Rezoning Transportation Analysis

Petition Number: 2023-091

From: Jake Carpenter, PE

Date	Description
9-28-23	First Review (NK)
10-26-23	Second Review (JP)

SCHEMATIC SITE PLAN

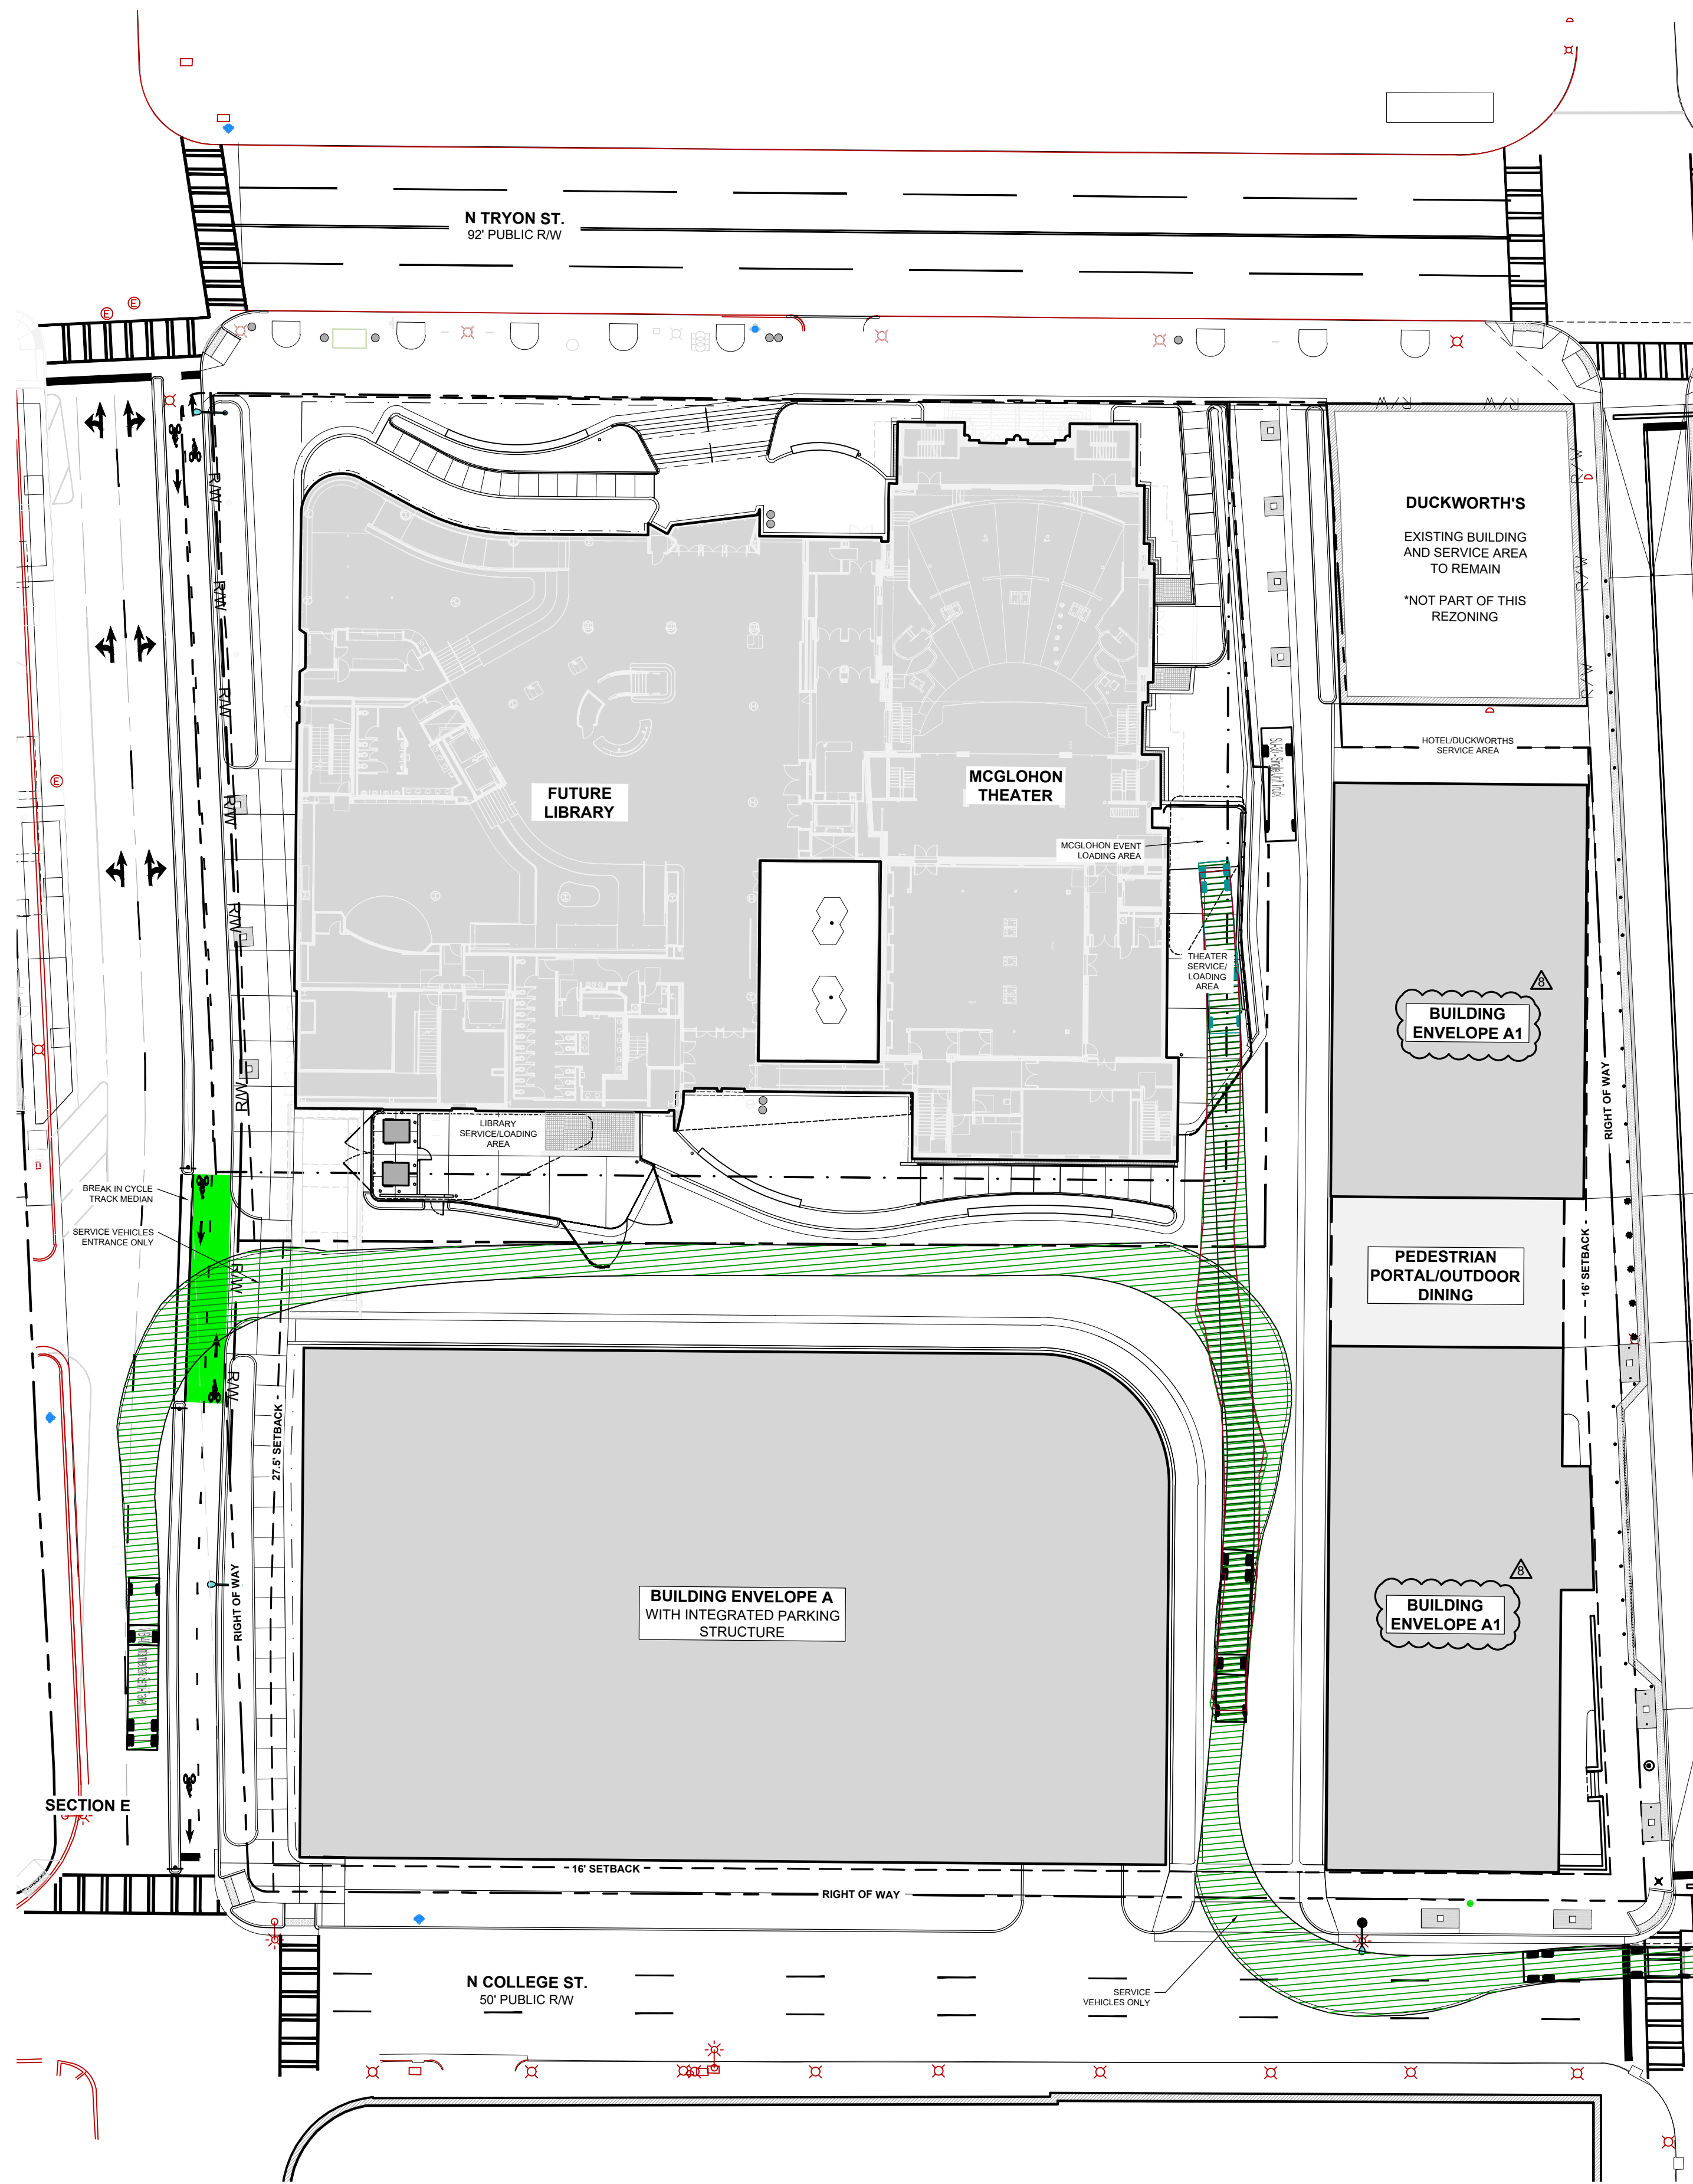
1. Curblines:

a. ~~East 6th Street:~~ The future location of curb and gutter is in its existing location.

b. ~~North Tryon Street:~~ The future location of curb and gutter is in its existing location.

c. ~~North College Street:~~ The future location of curb and gutter is in its existing location.

d. ~~East 7th Street:~~ The future location of curb and gutter is in its existing location.

- ~~3. Revise site plan and conditional note(s) to commit to dedicate right-of-way from the road centerline to 2' behind the shared use path. The site plan shall label and dimension the right-of-way from the road centerline.~~

Clarifying Comment 10.26.23: Either dedicate ROW or provide a sidewalk utility easement. SUE should be placed 2' behind the back of walk, or at the face of building where 2' cannot be obtained.

- 7. Outstanding Comment 10.26.23: Add a conditional note specifying "the Petitioner shall dedicate and convey in fee simple all rights-of-way to the City before the site's first building certificate of occupancy is issued. CDOT requests rights-of-way set at 2' behind back of sidewalk where feasible."**
